WELWYN HATFIELD COUNCIL – DEVELOPMENT CONTROL
DELEGATED REPORT

APPLICATION No:	N6/2010/1275/FP
------------------------	------------------------

The application seeks planning permission for the replacement of windows on stairwell and panels, formation of three ramps on footpath and dropped curb on Block one of Woodside House.

FIRST FLOOR PLAN AS PROPOSED

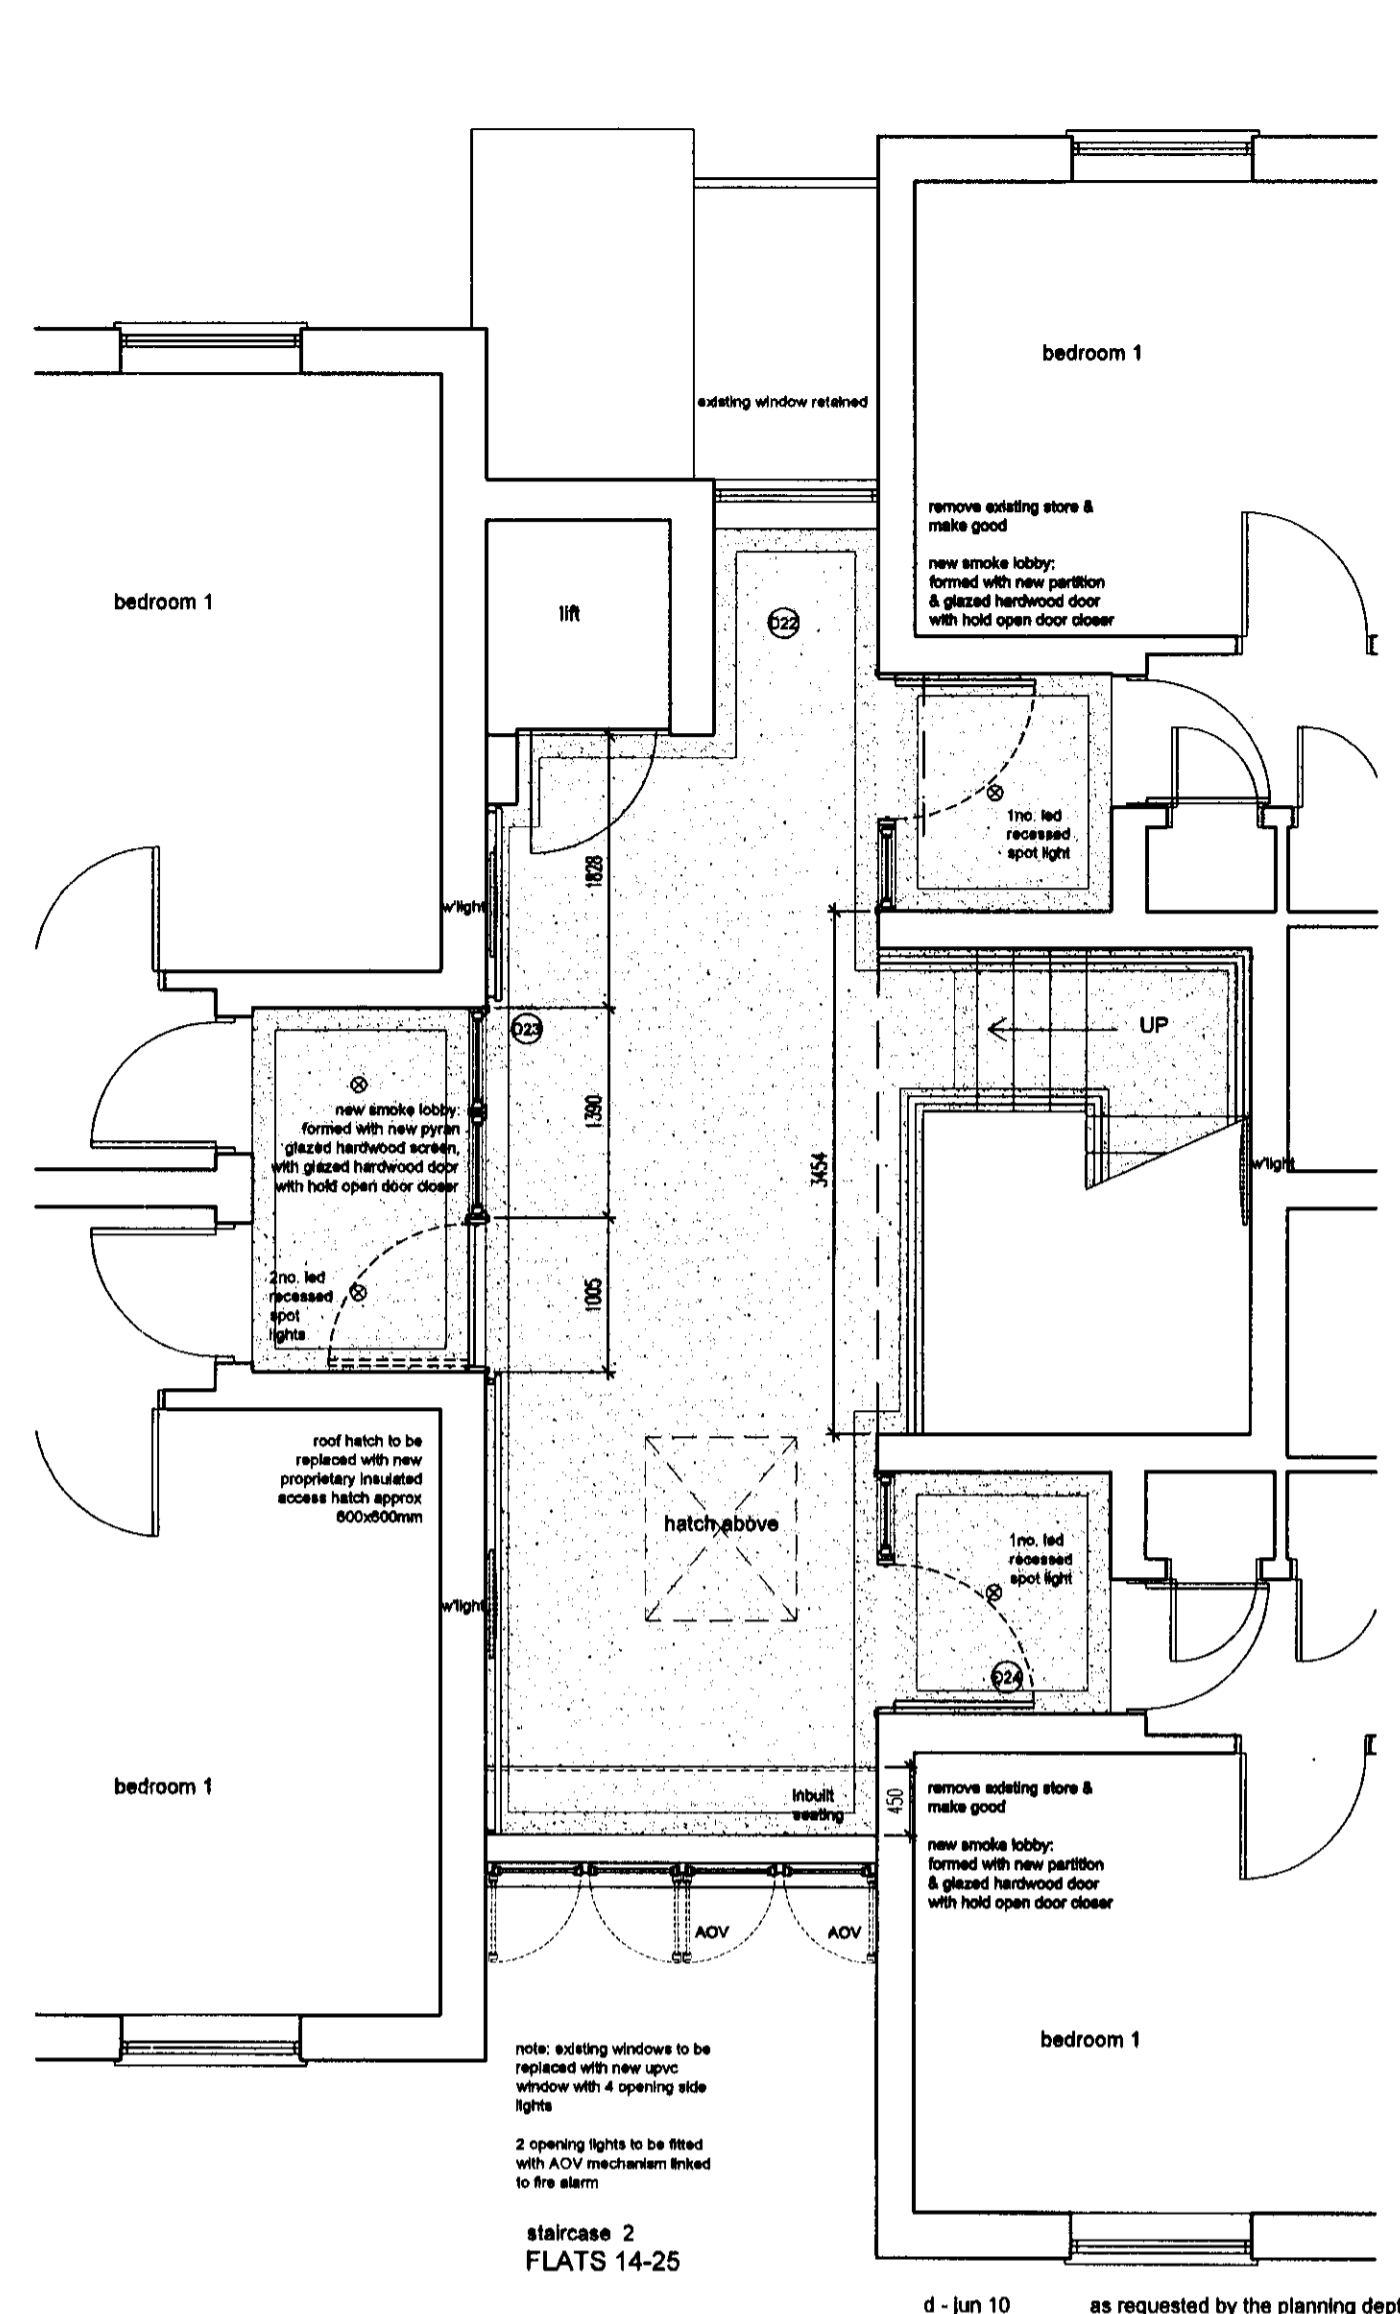
The proposed replacement windows would have four vertical panes which would include the same vertical pane in the large windows found in the building. They would be within the recessed element of the building and would be white uPVC. There is no objection to this as it is considered that it would not adversely harm the character and appearance of the building or the locality.
